Recommendation Report for Planning Permission for Works or Extension to a Dwelling

REF NO: EP/128/20/HH

LOCATION: 48 Angmering Lane
East Preston
BN16 2TA

PROPOSAL: Erection of a two storey rear extension. Existing brick house to be rendered in white with alterations to fenestration

Drawing No. 0010 Drawing Name: Proposed Elevations

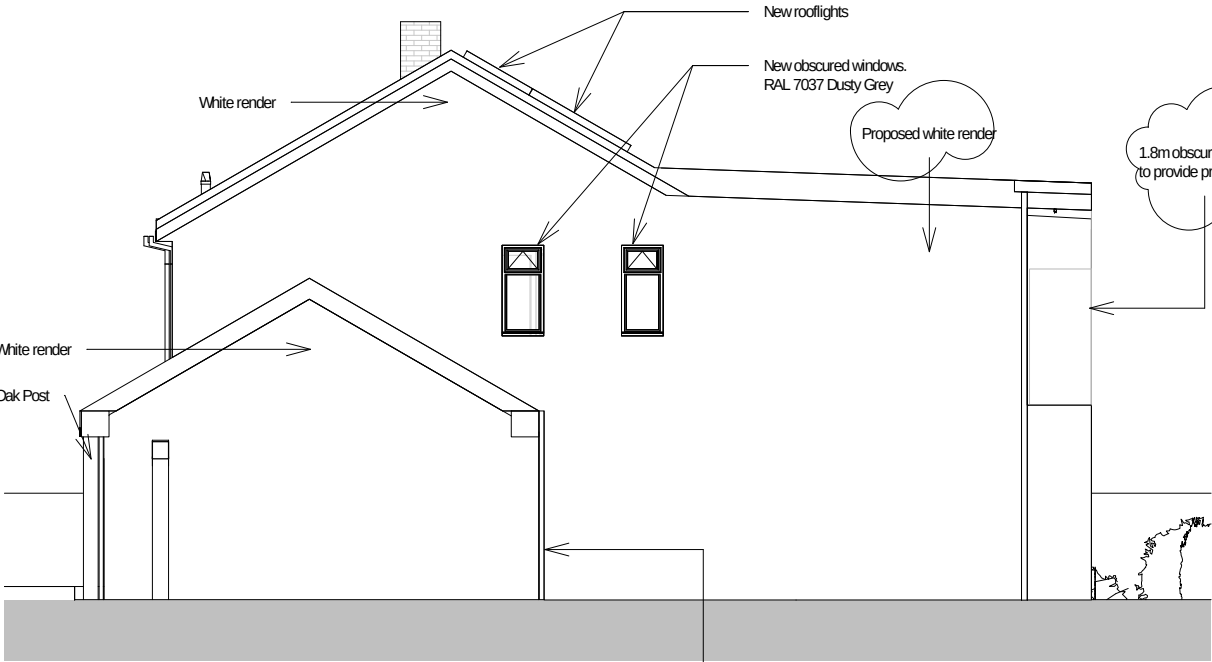
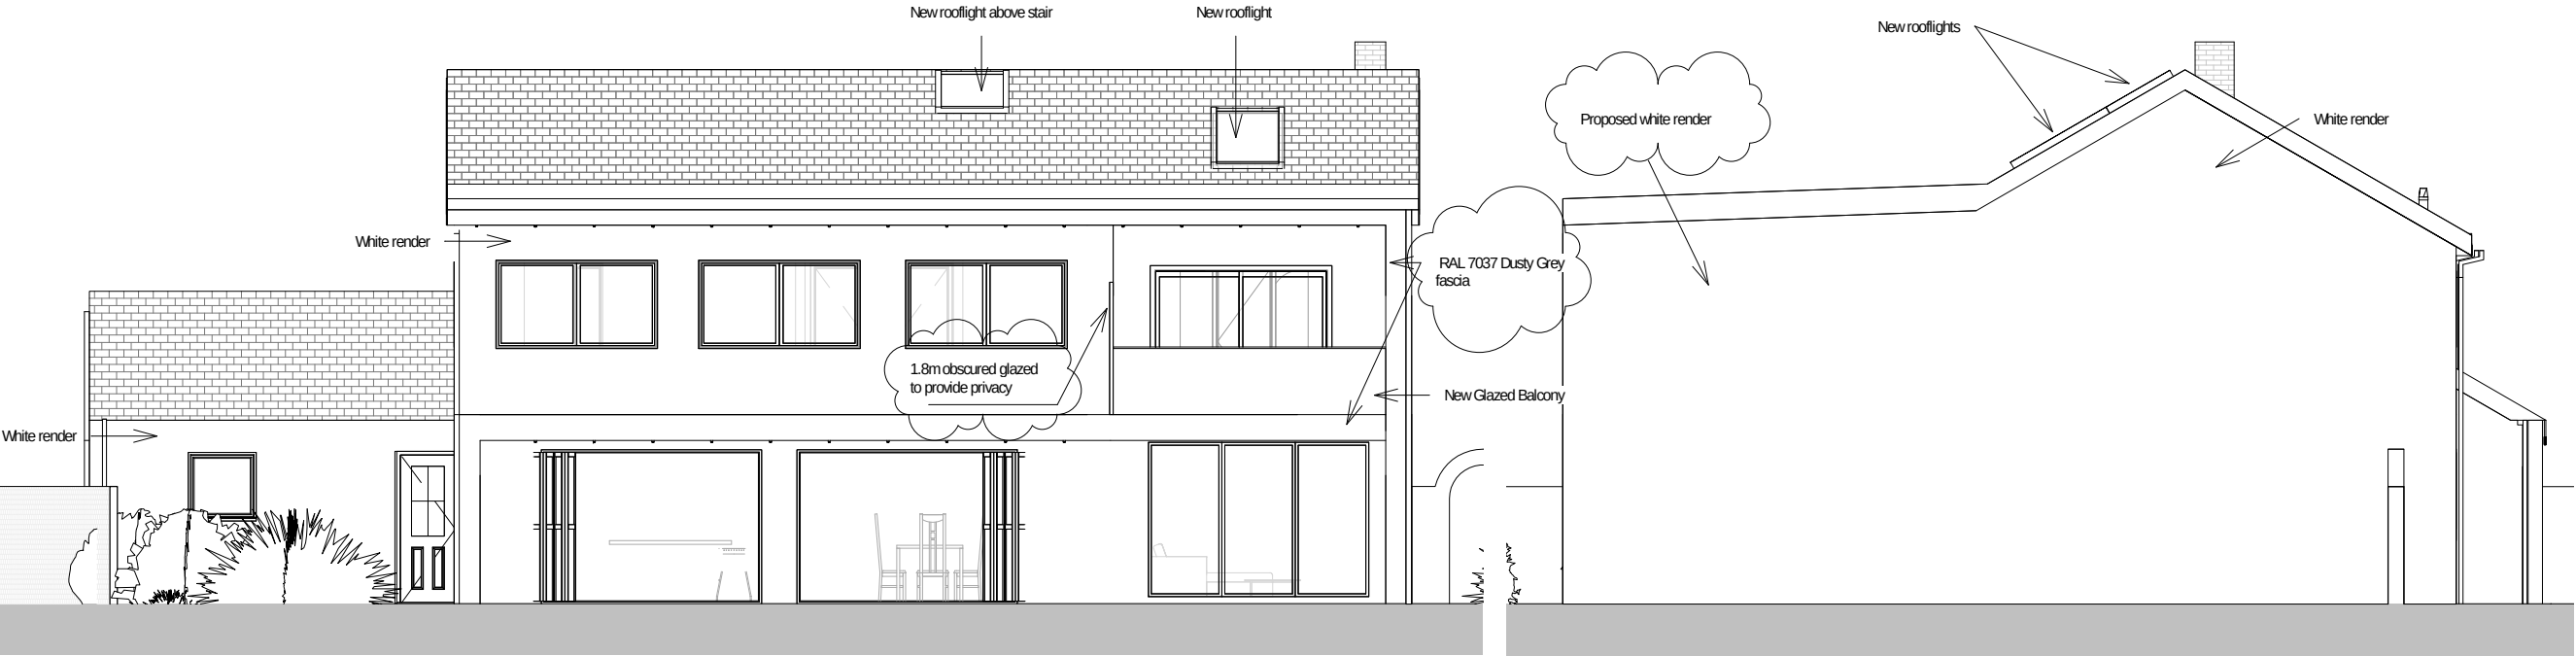
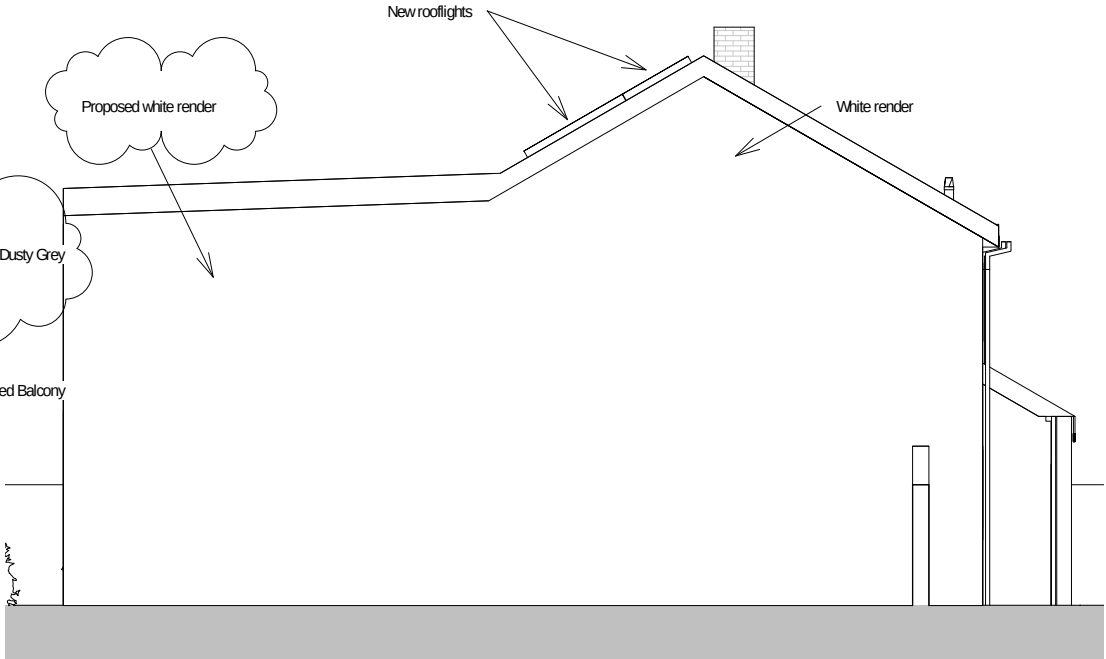
The balcony would have an enclosed side and as such any overlooking would be largely to the rear of the hosts garden.

The new proposed windows in the south elevation at first floor level will be conditioned to be obscure glazed and fixed shut so as to avoid any unacceptable overlooking.

- 3 The new windows on the first floor of the south elevation of the building shall at all times be glazed with obscured glass and fixed to be permanently non-opening up to 1.7m from the finished ground floor level. The proposed screening to the balcony as shown in plan number Dwg.No. 0010 Rev P2 dated Aug 2020 will be put up before its use as a balcony and retained as such thereafter.
